**Chancel Cottage, Fir Lane, Steeple Aston, Bicester, OX25 4SF****Case Officer:** Ernest Addae-Bosompra      **Recommendation:** Refuse**Applicant:** Mr Justin Grainger**Application Description:** Internal alterations, external alterations (including insertion of six rooflights), demolition of attached outbuildings and erection of single storey extension**Report Type: Delegated Decision****1. Site Description and Proposed Development**

Fig.29 - Proposed First Floor Plan

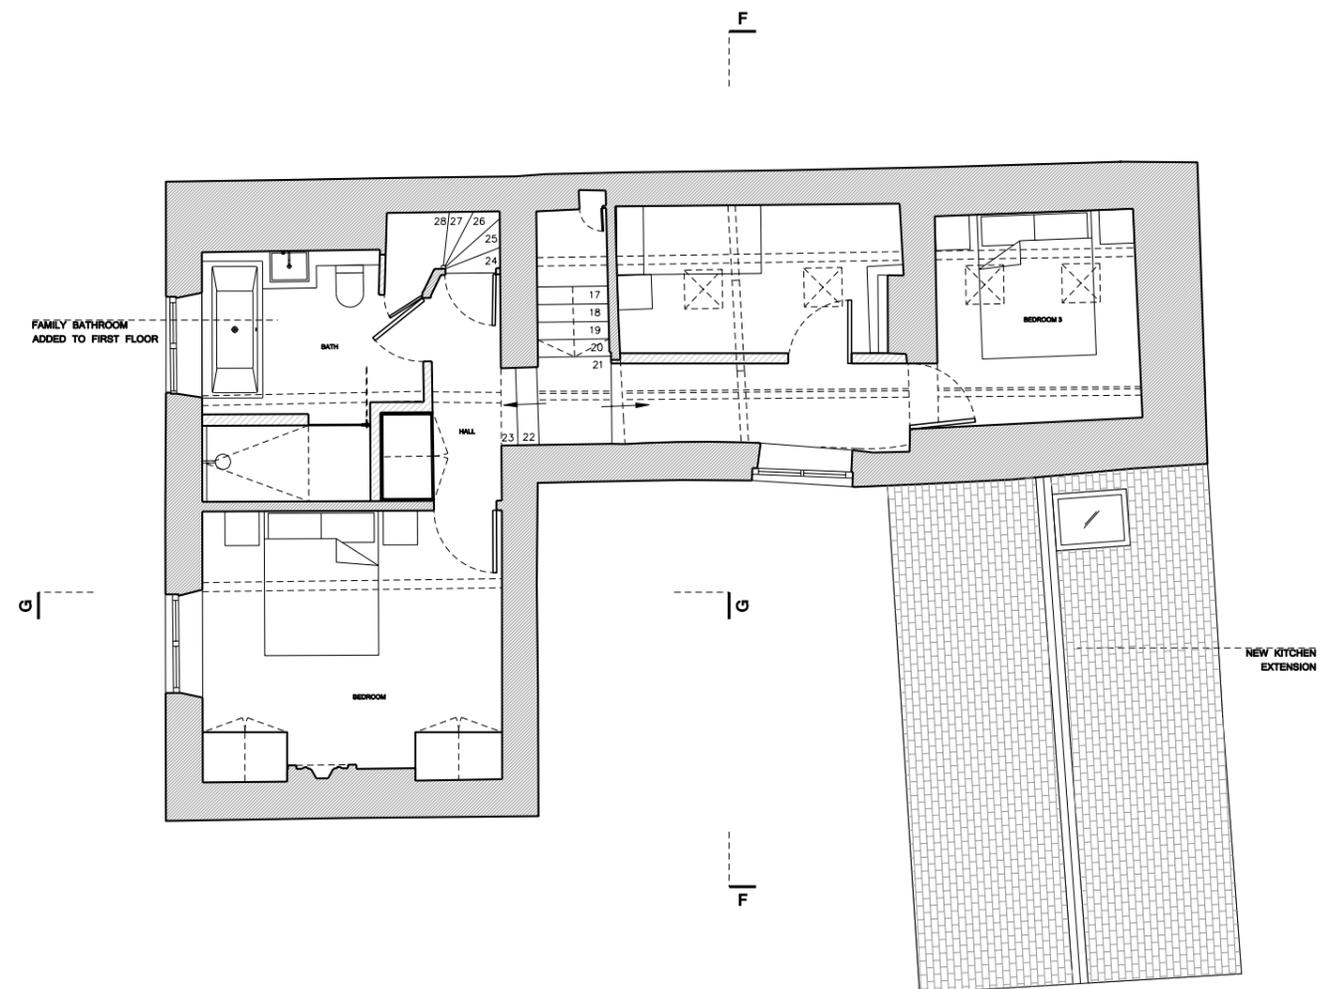
- 5.14 However, the proposal to form an additional doorway at first floor level is considered to have a more significant impact. The doorway is between the original stable range and the later 19<sup>th</sup> century addition, which was constructed as a physically separate structure. The ground floor area of the building has been brought into domestic usage, but the first floor area remains unconverted and unused. There is evidence of a former opening at first floor level which has since been blocked up. It is considered that there would be some harm to the significance of the site if this element of the building were to be converted, although this would need to be weighed against the public benefit of bringing this section of the building into use with the associated benefits of better maintenance.

- 5.16 Rooflights are not a characteristic element of simple, vernacular cottages such as this one and would have a detrimental impact on the character and appearance of the heritage asset. Although proposed to be set flush within the roof slope, the cumulative impact of the number of rooflights proposed is considered to cause substantial harm to the character and appearance of the listed building. The proposed use of the roof space for a further bedroom is considered acceptable in principle.
